Re: Falcon Marketplace Final Plat (SF-19-001 CDR-16-007)

Please accept this response letter to your comments dated June 11, 2019

We trust you find our responses to the 3rd review of the Falcon Marketplace Final Plat acceptable. We look forward to working with the County in processing the submittal. Please call if you have any questions or require any additional information.

MERIDIAN ROAD  
TURN LANE  
EXTENSION

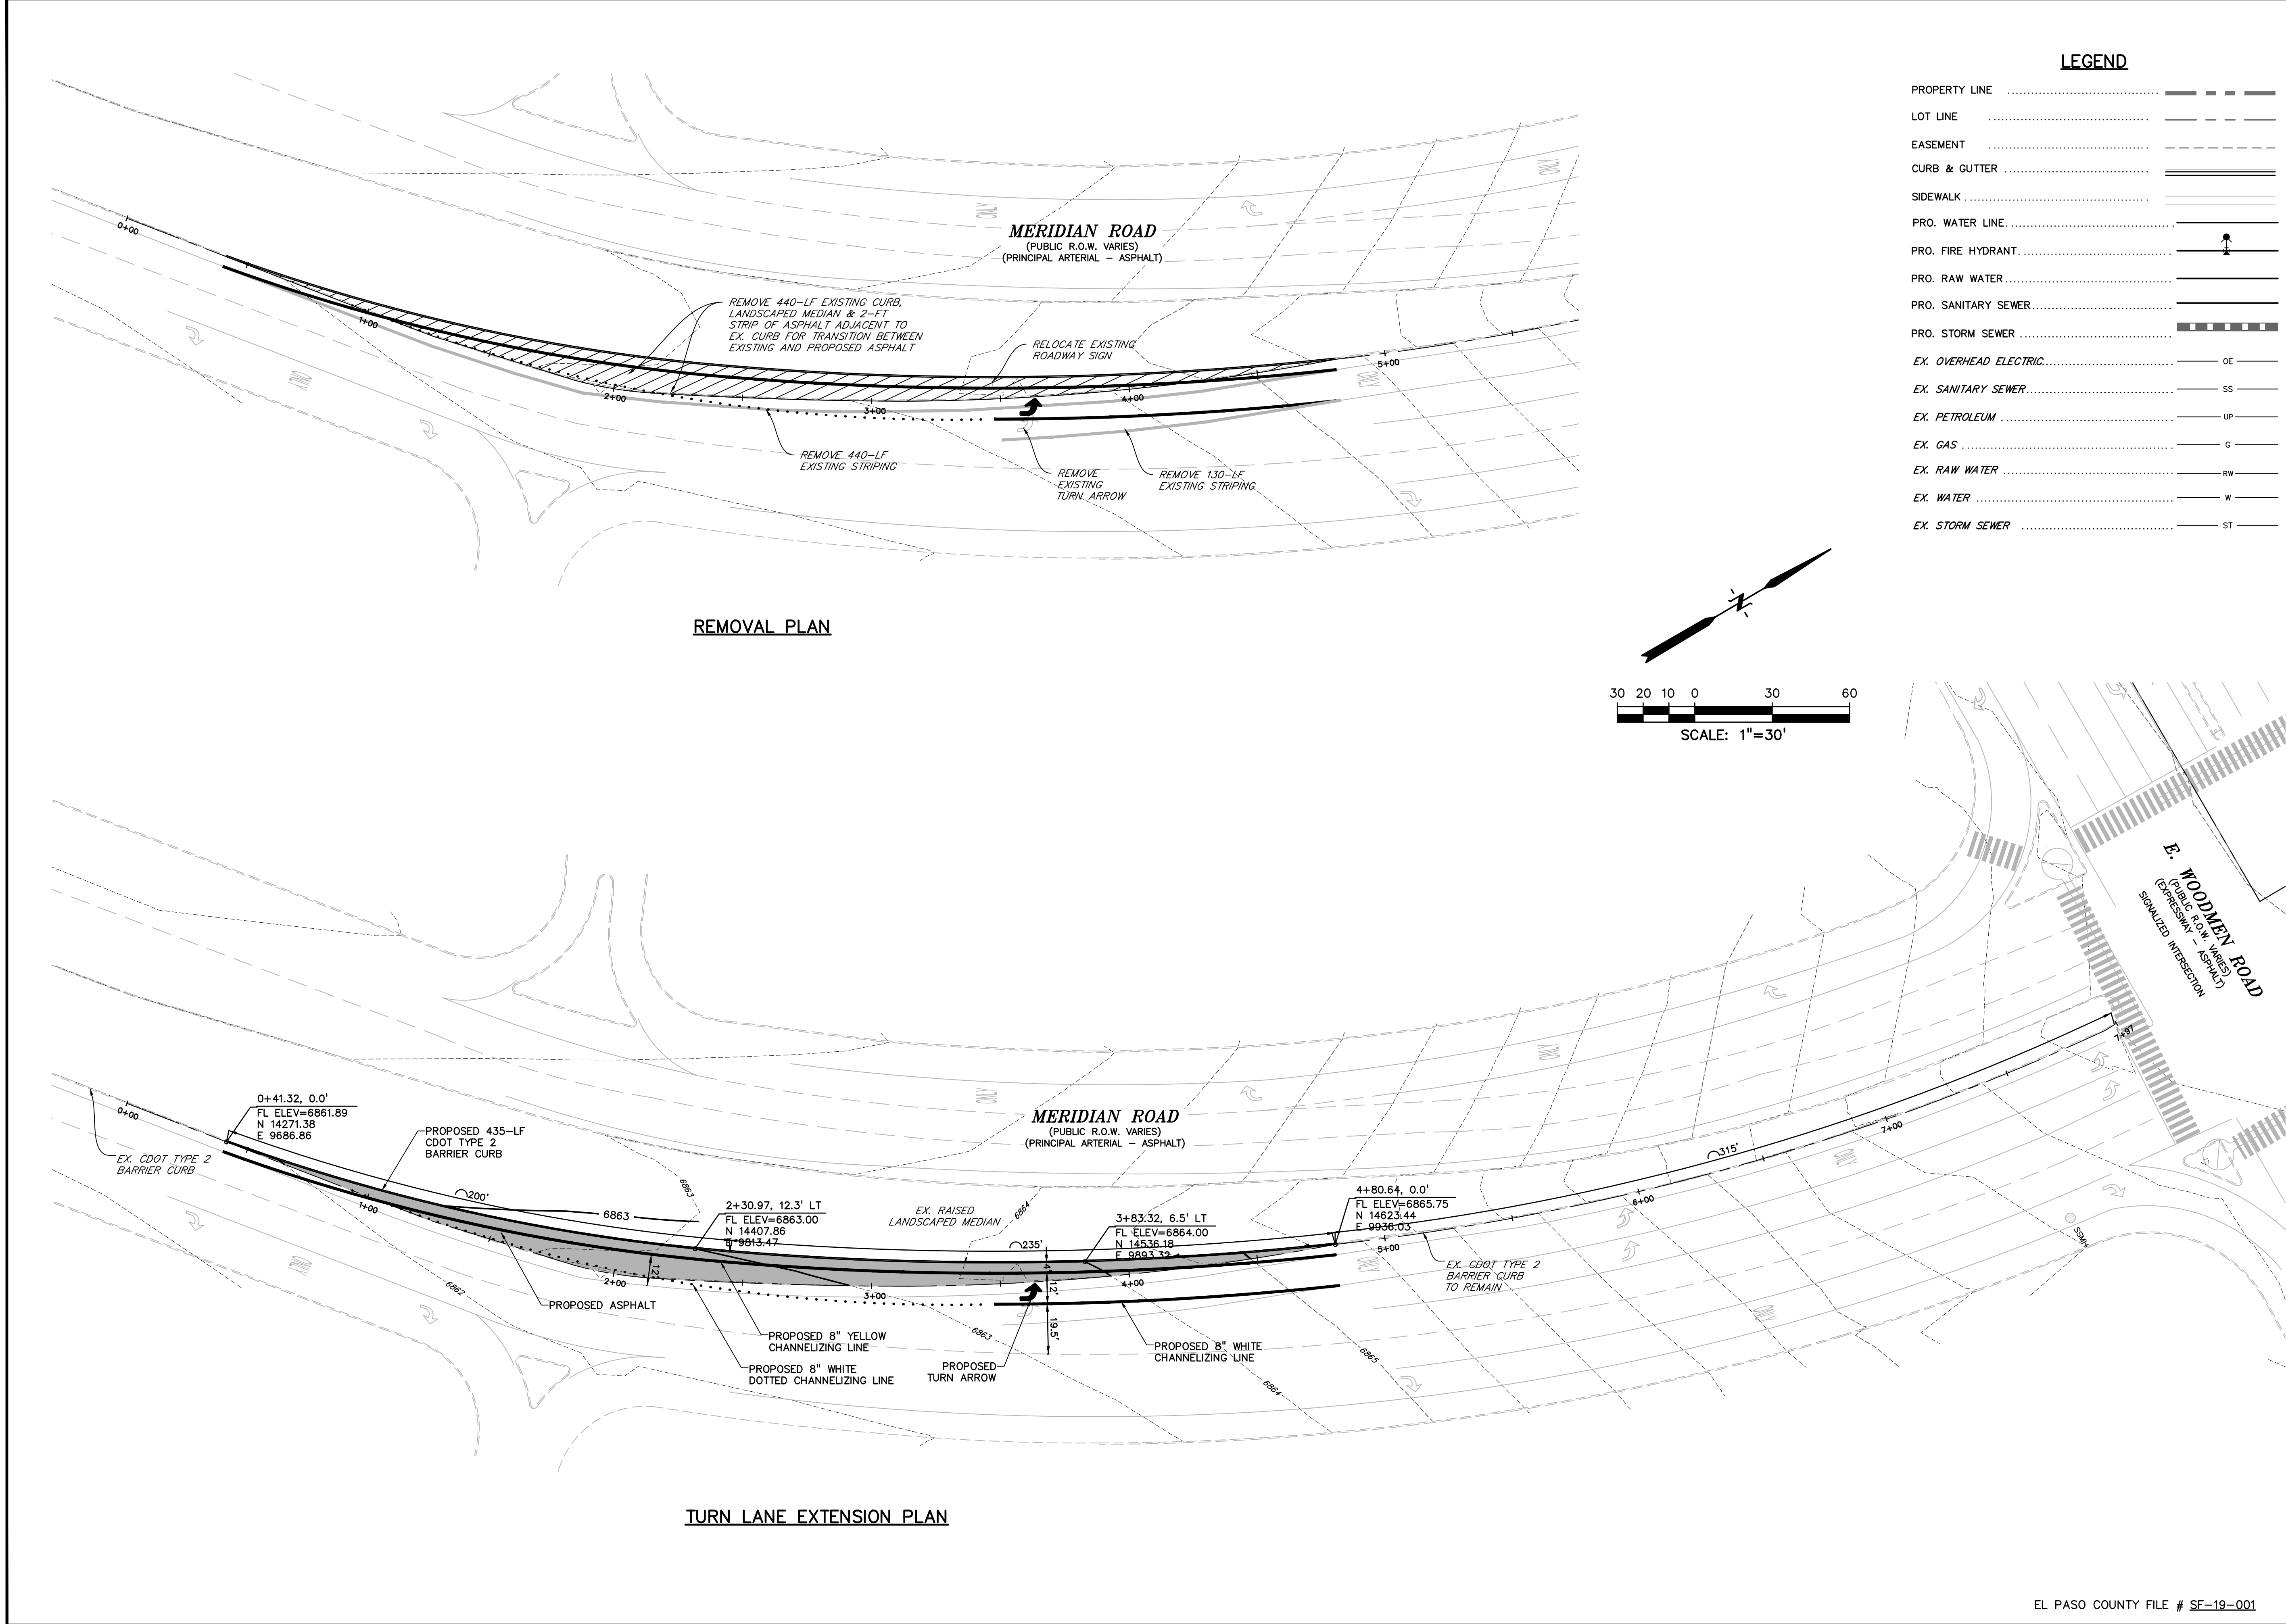
14. **On Sheet C4.10 show all drainage/utility facilities next to the lane extension. Verify that guardrail is not required. Facilities added to plan sheet, no guardrail required.**
